Application for a non-material amendment following a grant of planning permission.
Town and Country Planning Act 1990

Former Arla Dairy

Redevelopment of the site to provide a foodstore with ancillary cafe (Class A1) and ancillary petrol filling station, cinema (Class D2), 5 x restaurant units (Class A3), and residential development consisting of 132 units, together with new vehicle and pedestrian accesses, car parking, servicing areas, landscaping arrangements, and other associated works.

66819/APP/2014/1600

project	Arla Dairy Site, Victoria Road South Ruislip	drawn by	GJ
status	Planning	checked by	IG
title	Planting Plan Plaza	date	09.01.14
Xref	xref	scale	1:250 @A1
drawing No	1061-201	revision	H

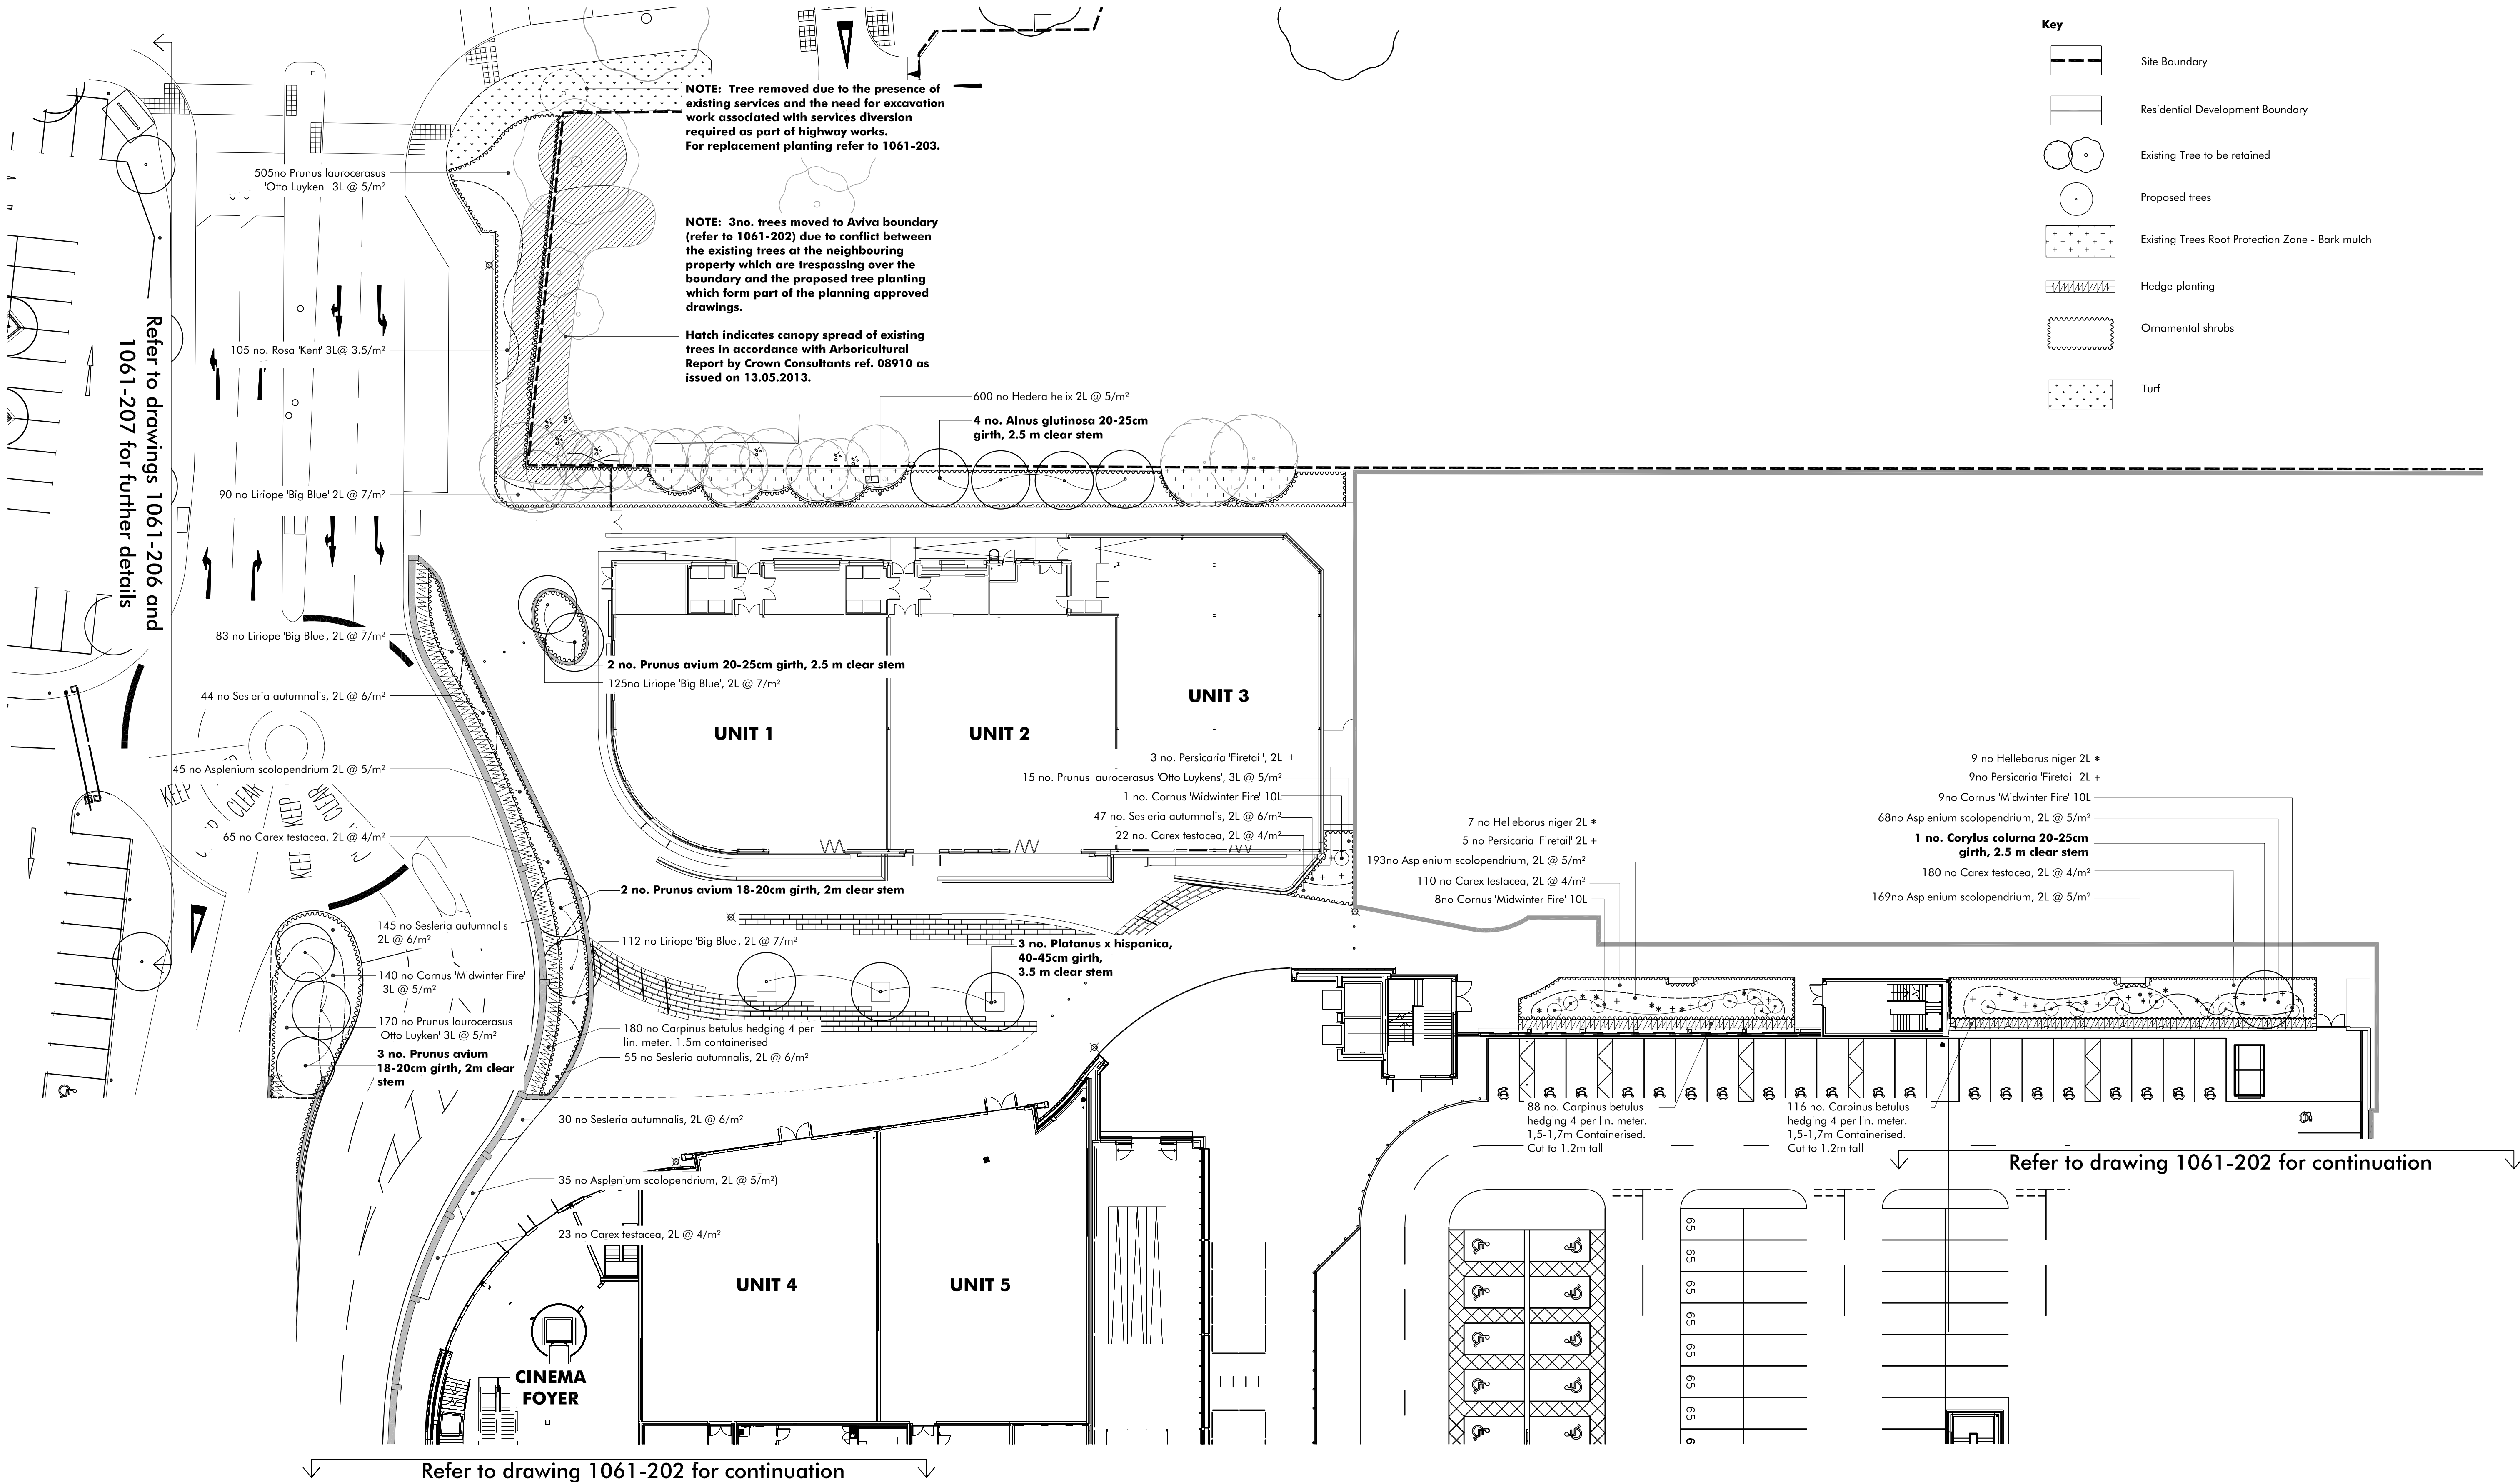
1. Omission of cows and introduction of a sculpture (details to be confirmed).
2. Boundary fence near to entrance - increase in height to 2.1m and boarded both sides

5. Add sign to entrance fence (indicative - will be subject to a separate application for advertisement consent)
6. Trees to entrance adjacent to site boundary - redistribute elsewhere across site.

Macgregor • Smith Landscape Architecture				
project	Arla Dairy Site, Victoria Road South Ruislip	drawn by	AS	
status	Planning	checked by	IG	
title	Hard Landscape Plan 1 of 3	date	09.01.14	
Xref	arch-sk109-bound	scale	1:250 @A1	
drawing No	1061-301	revision	M

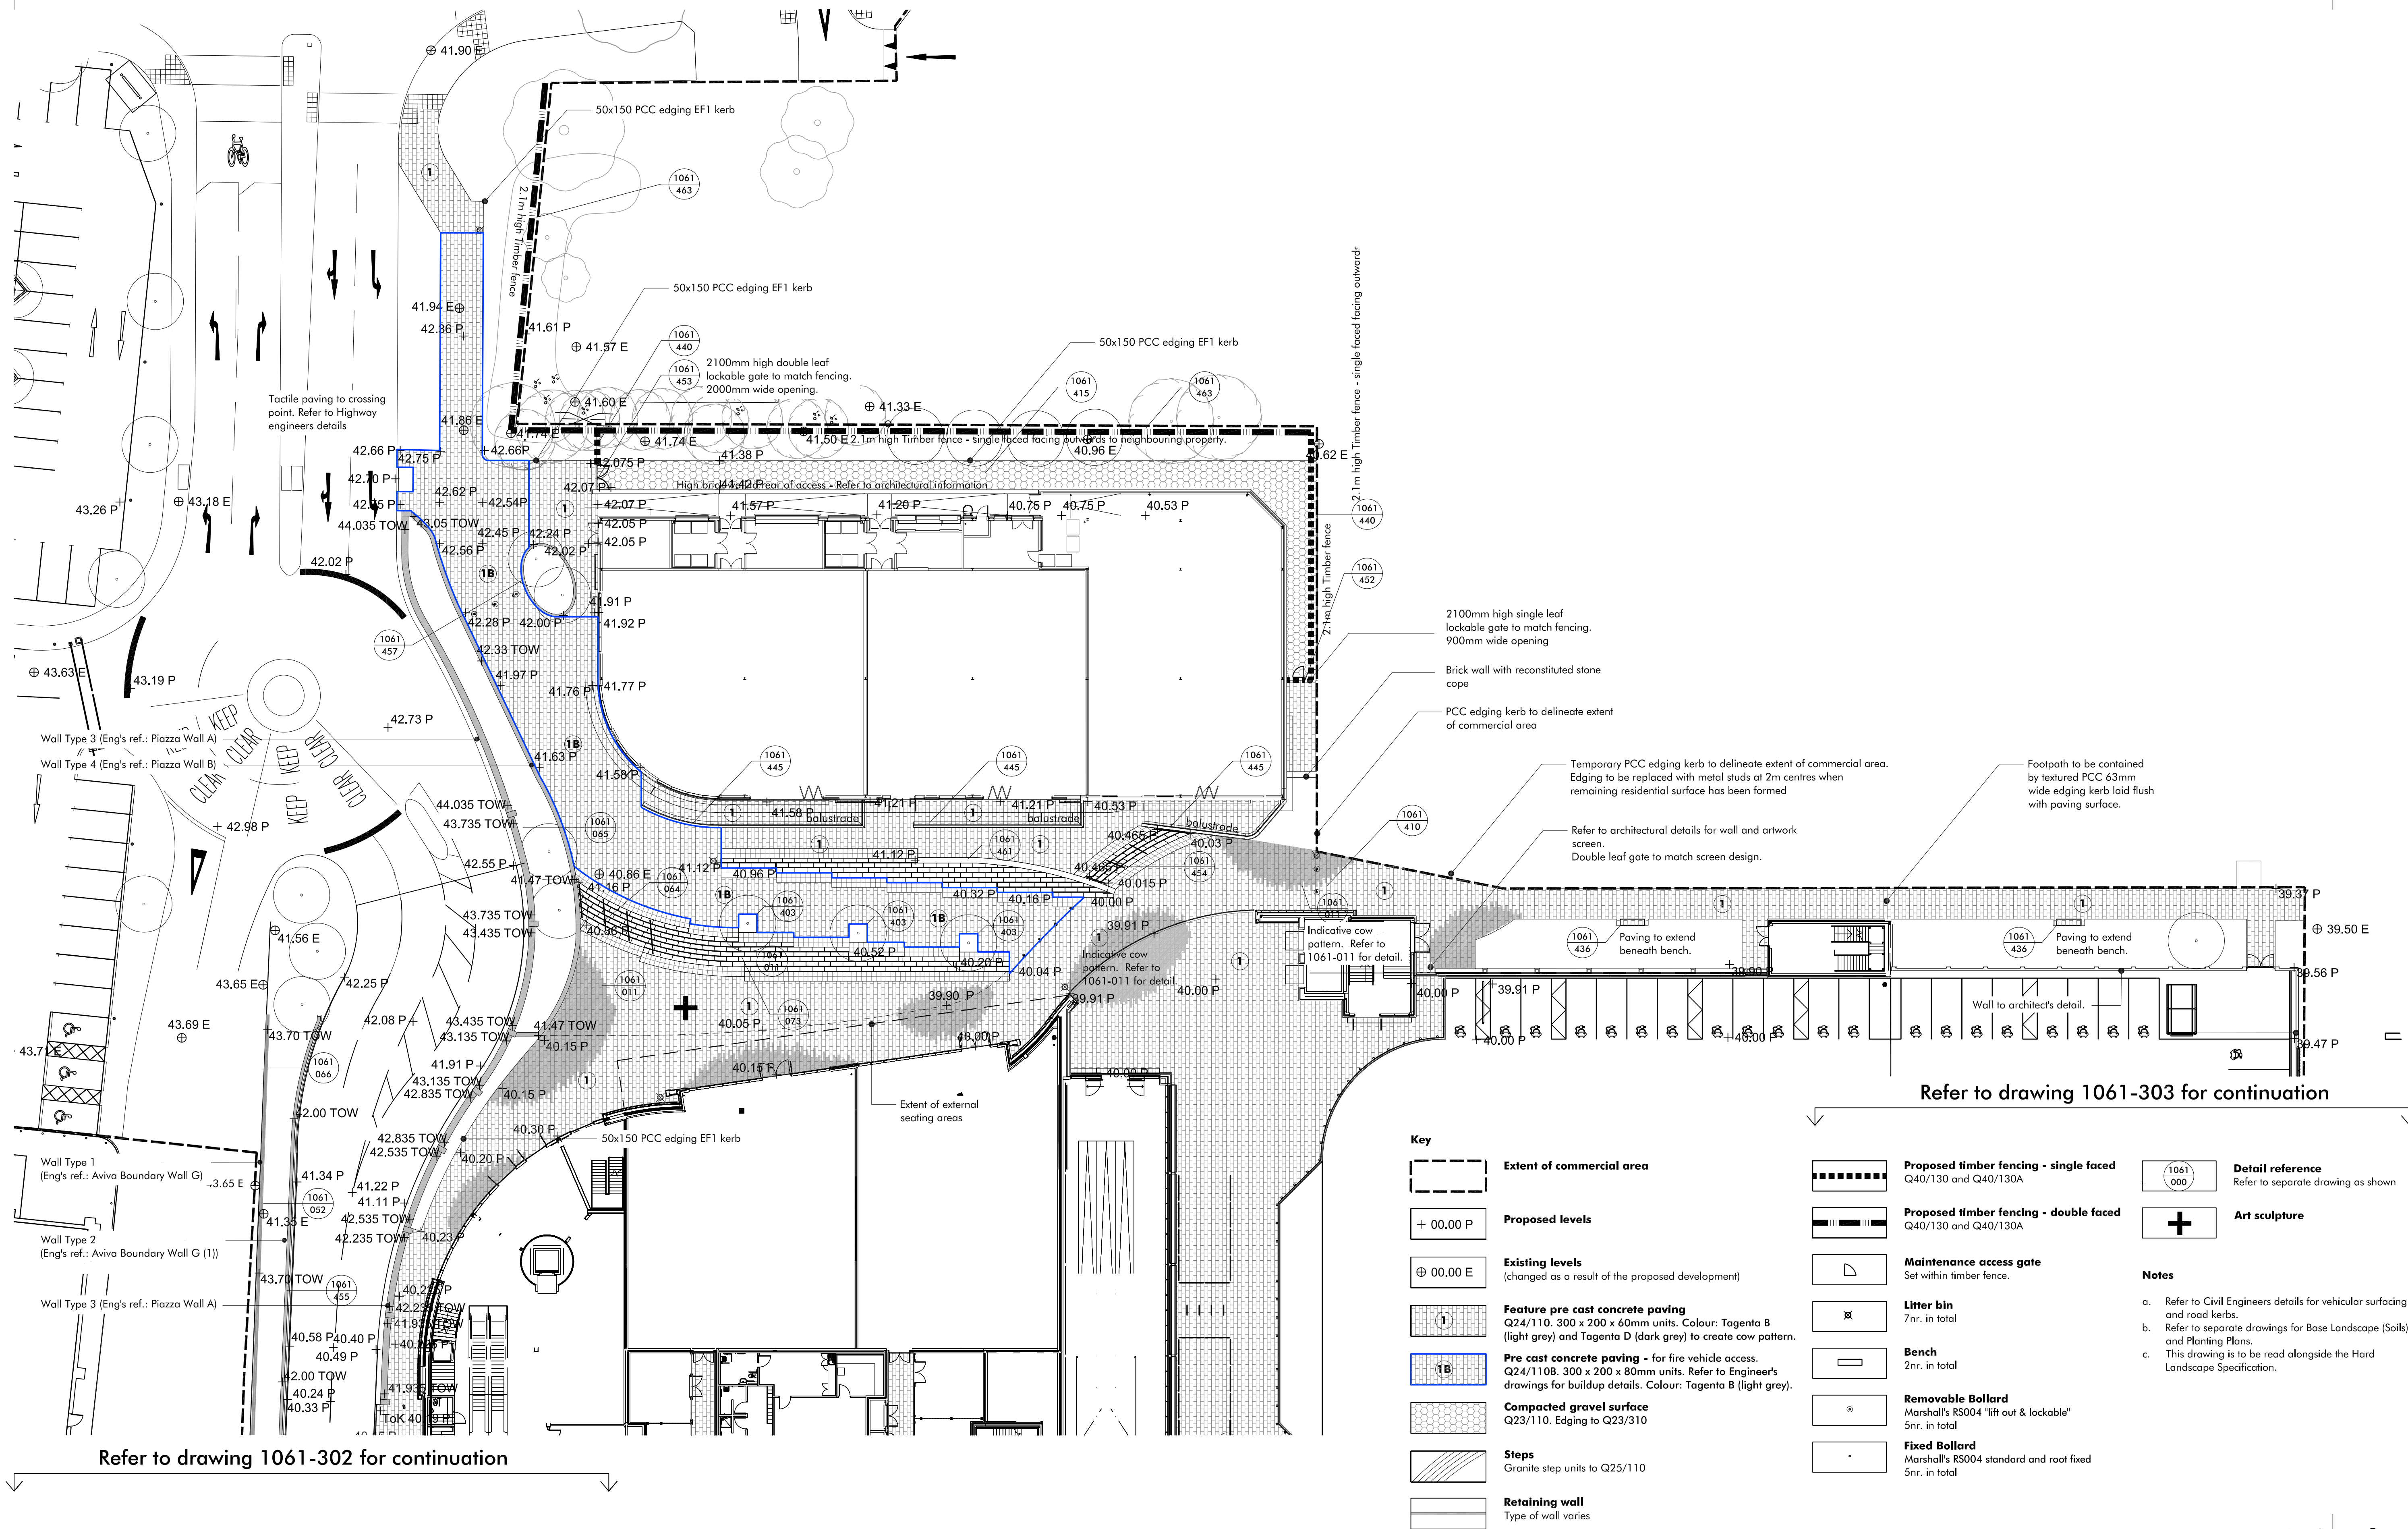
8. Change to landscaping at the site entrance (from hard to soft to align with highway approved drawings)
9. Bollards – Introduce 3Nr additional bollards (2nr between commercial and resi sites; 1nr near cinema entrance) and relocate 3Nr bollards on fire tender access road adjacent to small island near Unit 1.

Macgregor • Smith Landscape Architecture			
project	Arla Dairy Site, Victoria Road South Ruislip	drawn by	AS
status	Planning	checked by	IG
title	Hard Landscape Plan 3 of 3	date	09.01.14
Xref	arch-sk109-bound	scale	1:250 @A1
drawing No	1061-303	revision	I

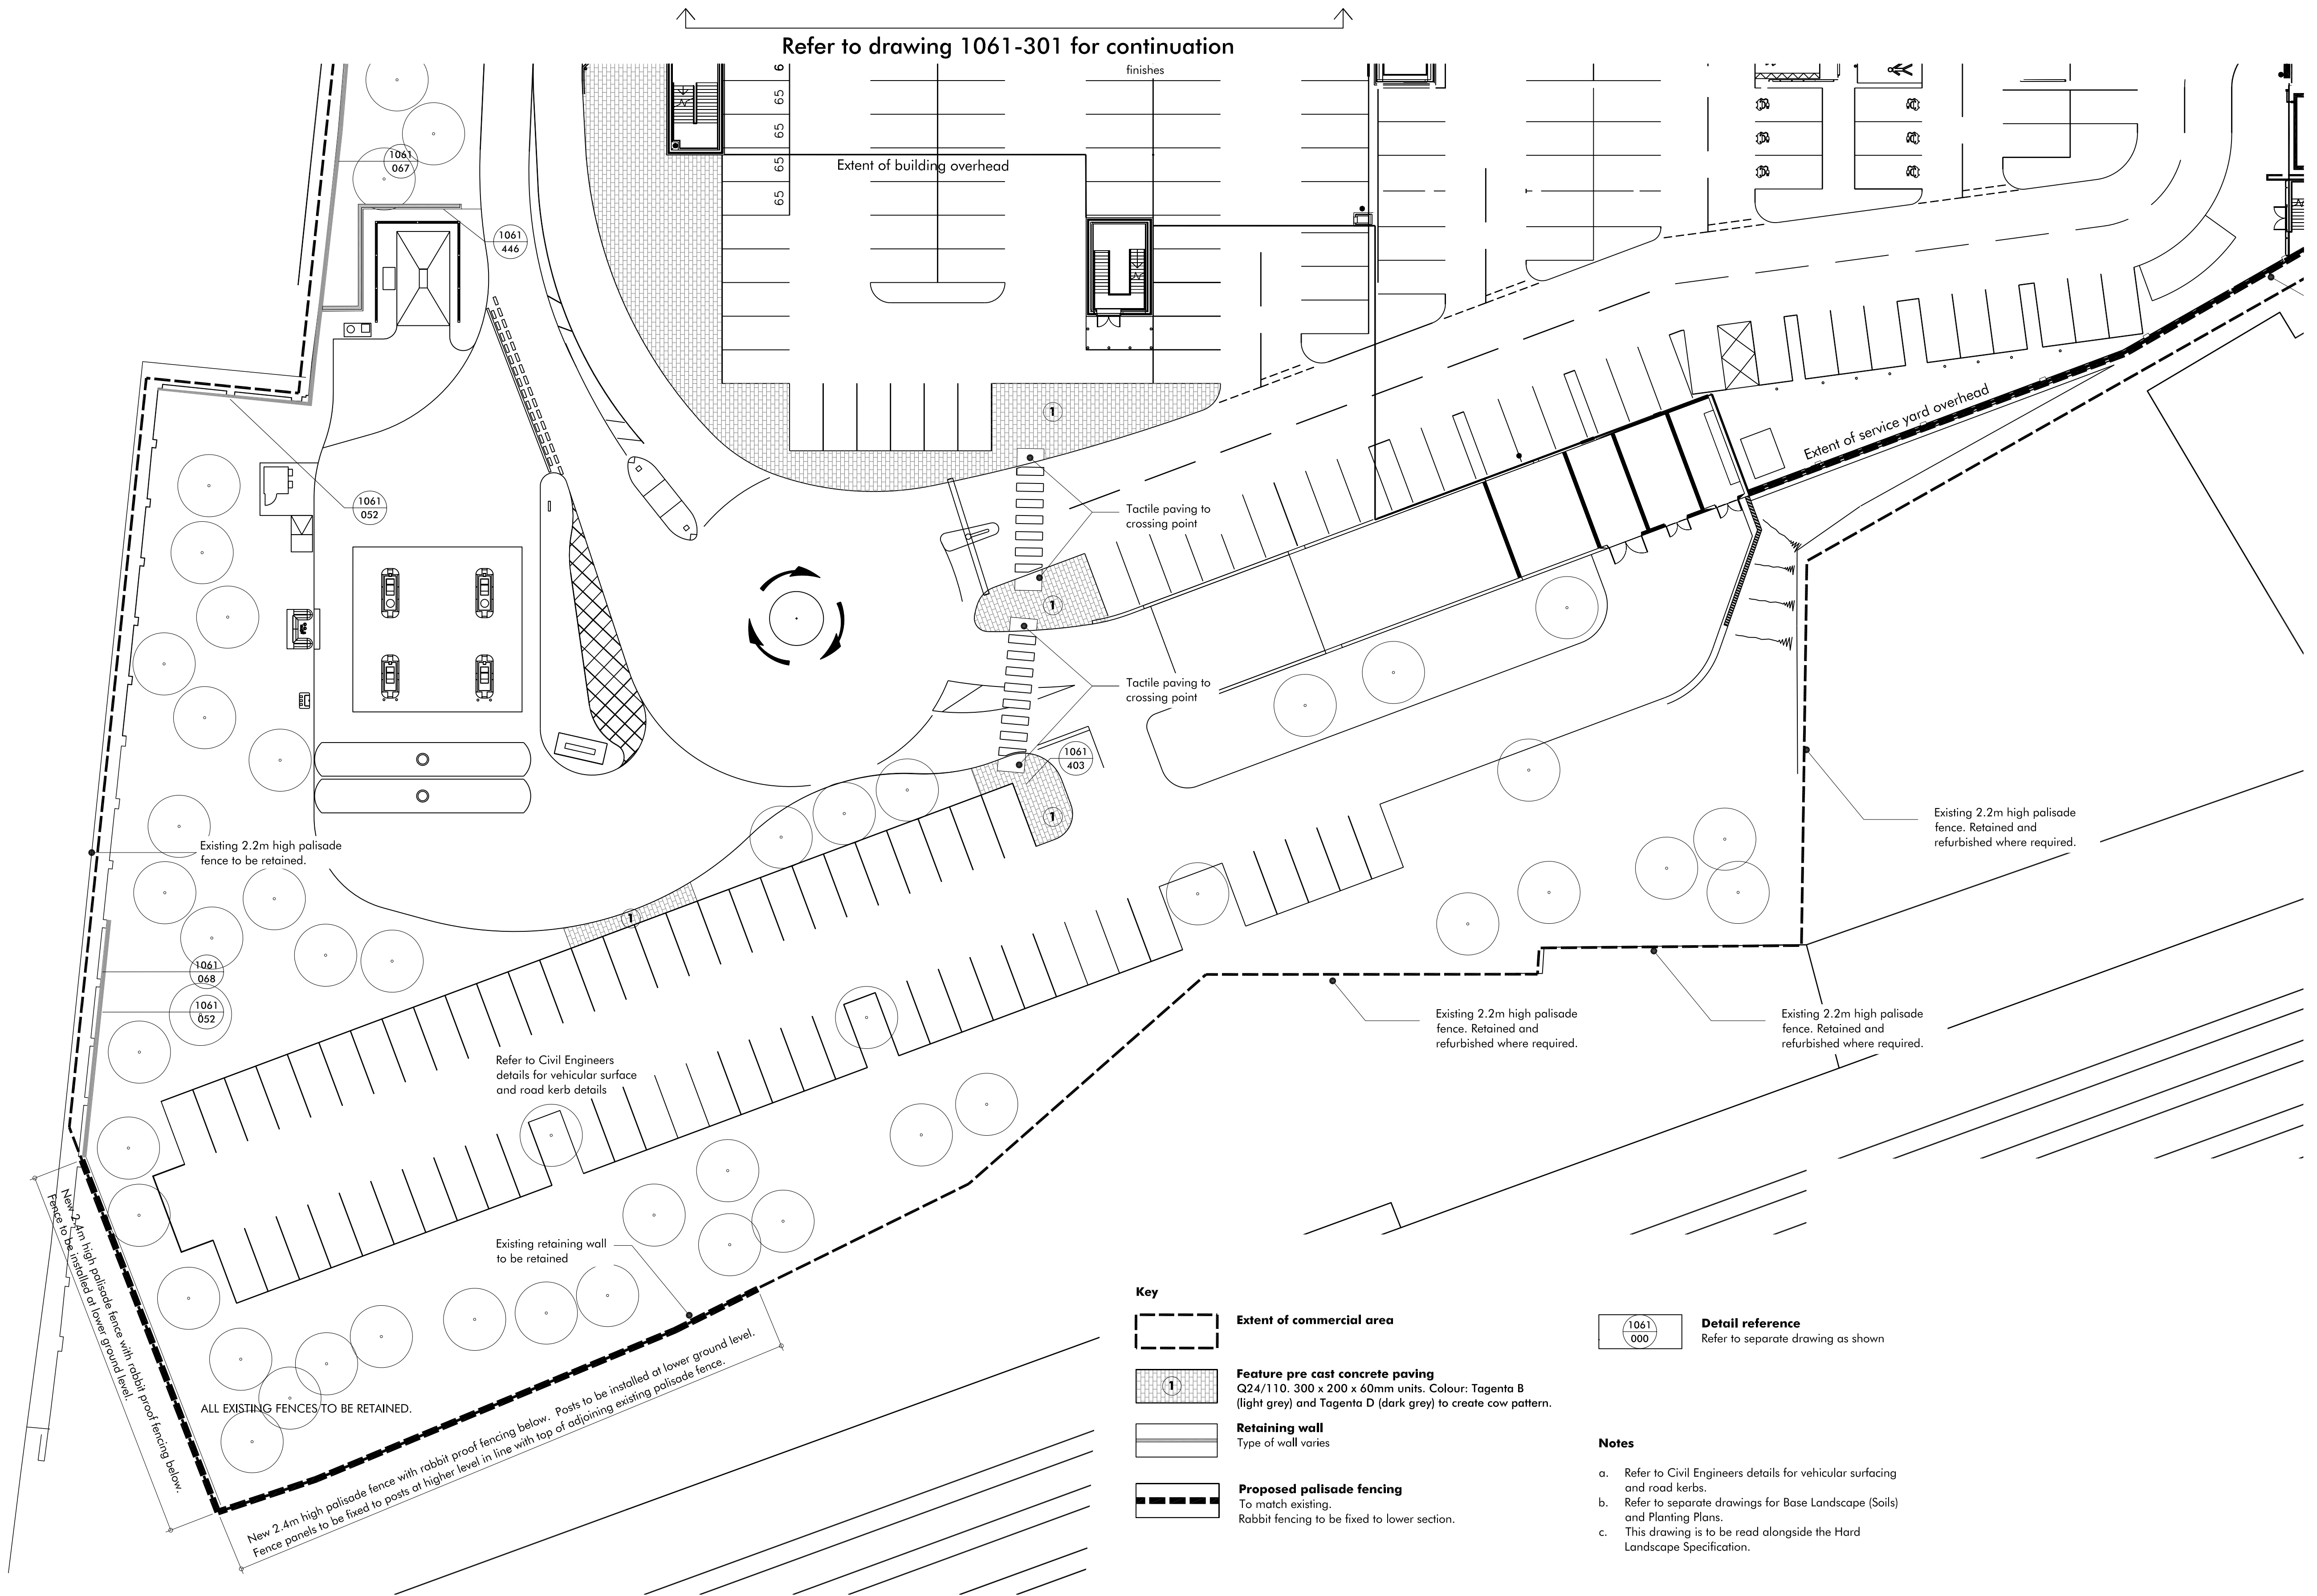
10. New 2.4m High Boundary Palisade Fence to south west corner of site adjacent to railway embankment (see drawing 1061-303 Rev I)
